From: Dan Young
Sent: Wednesday, March 12, 2025 10:28 AM
To: Ellie Myers
Subject: RE: AU-25-00003 Merten- Notice of Application

Subject: AU-25-00003 Merten- Notice of Application

Please review the following Accessory Dwelling Unit: AU-25-00003 Merten. Any comments need to be received by **5PM on February 19th, 2025**.

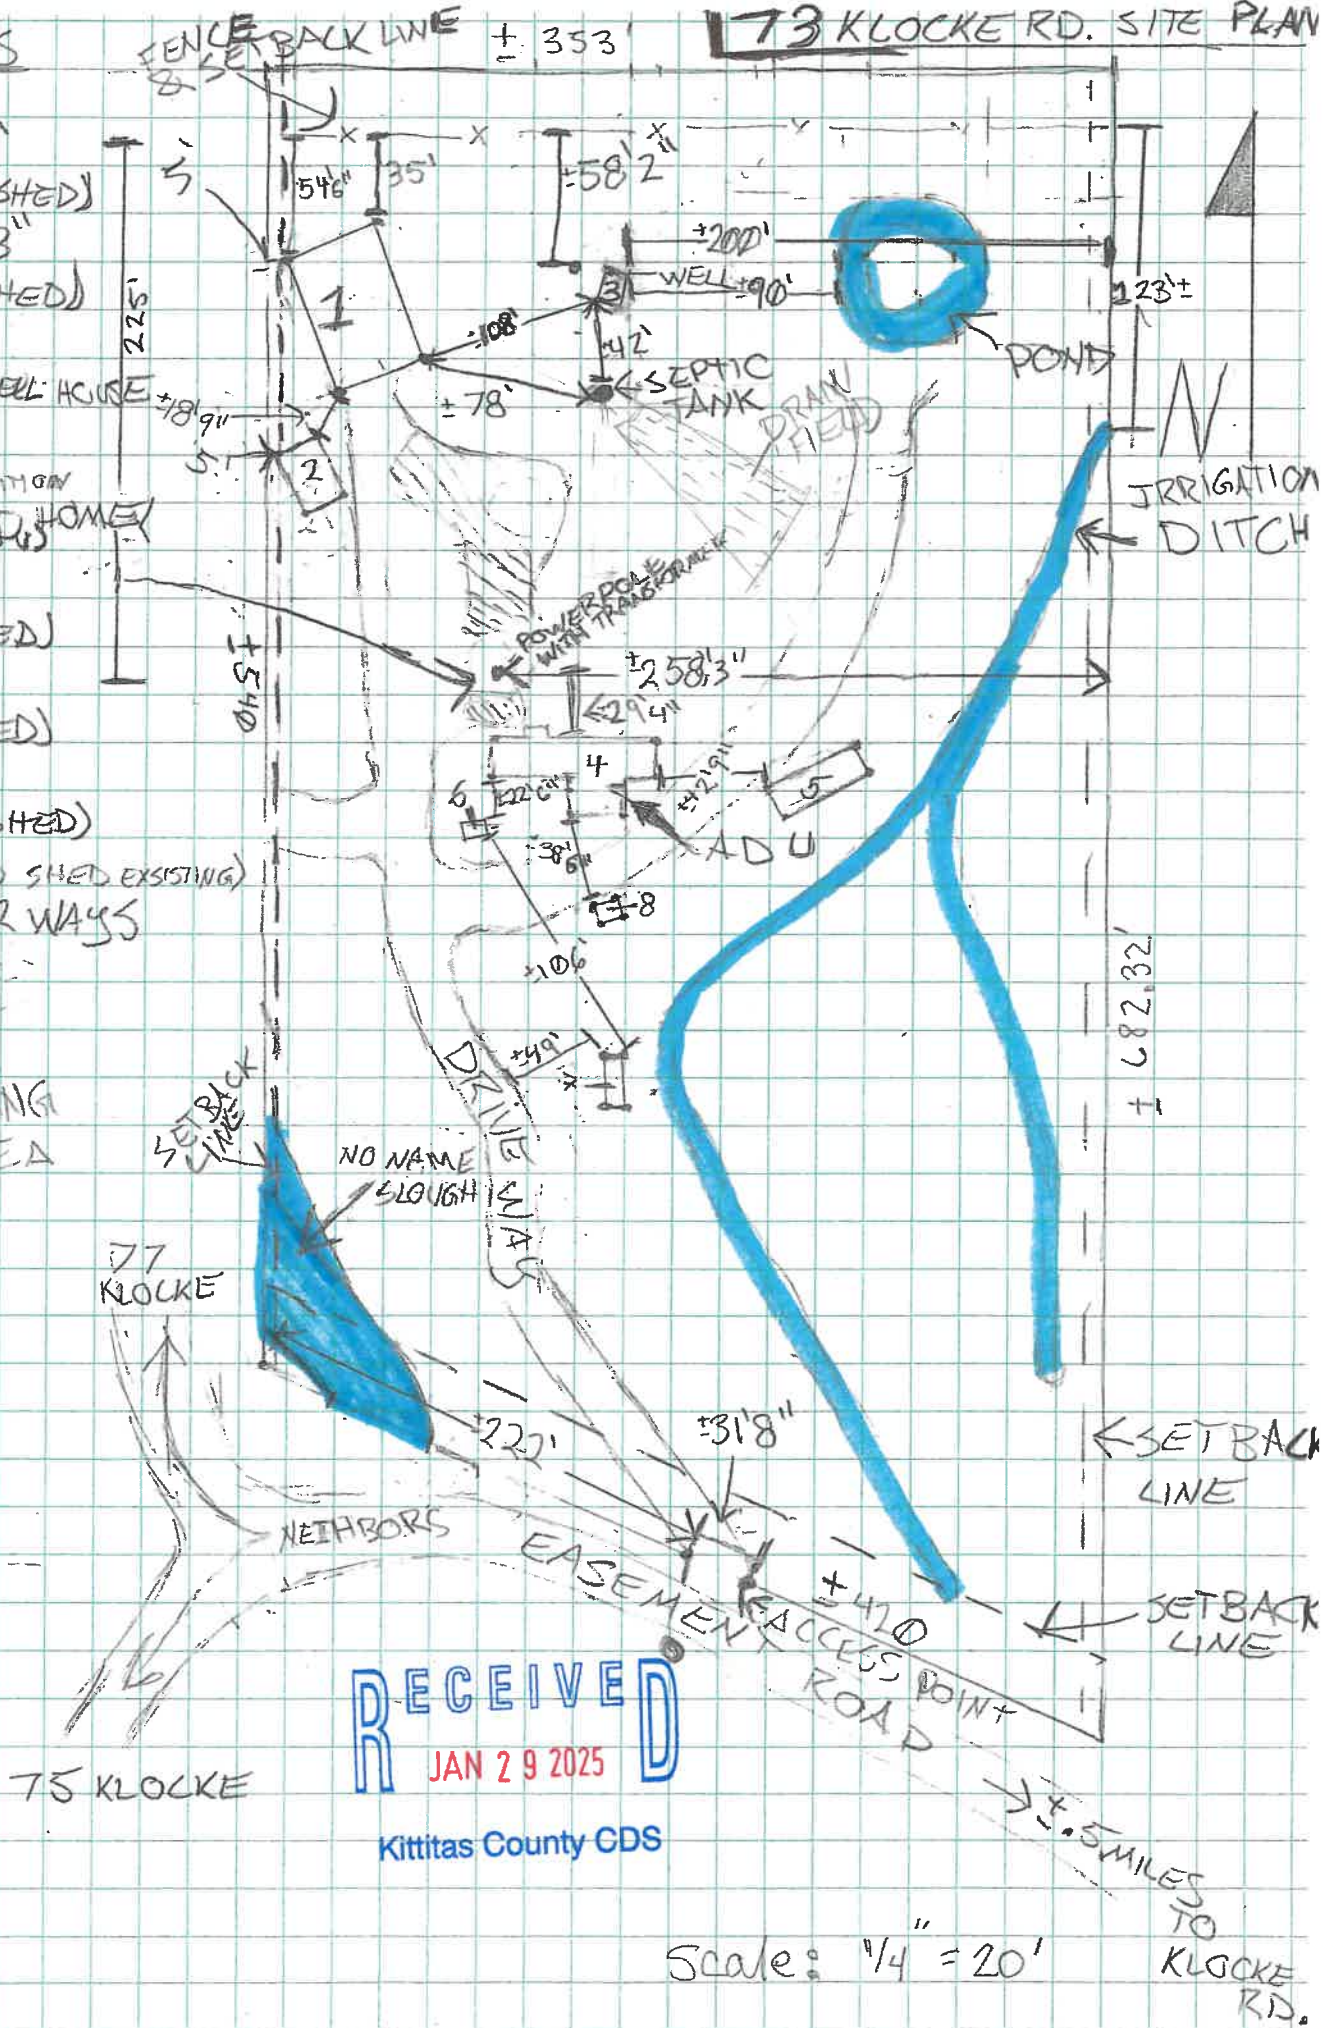
Driveway to meet road standards for width and turnarounds?
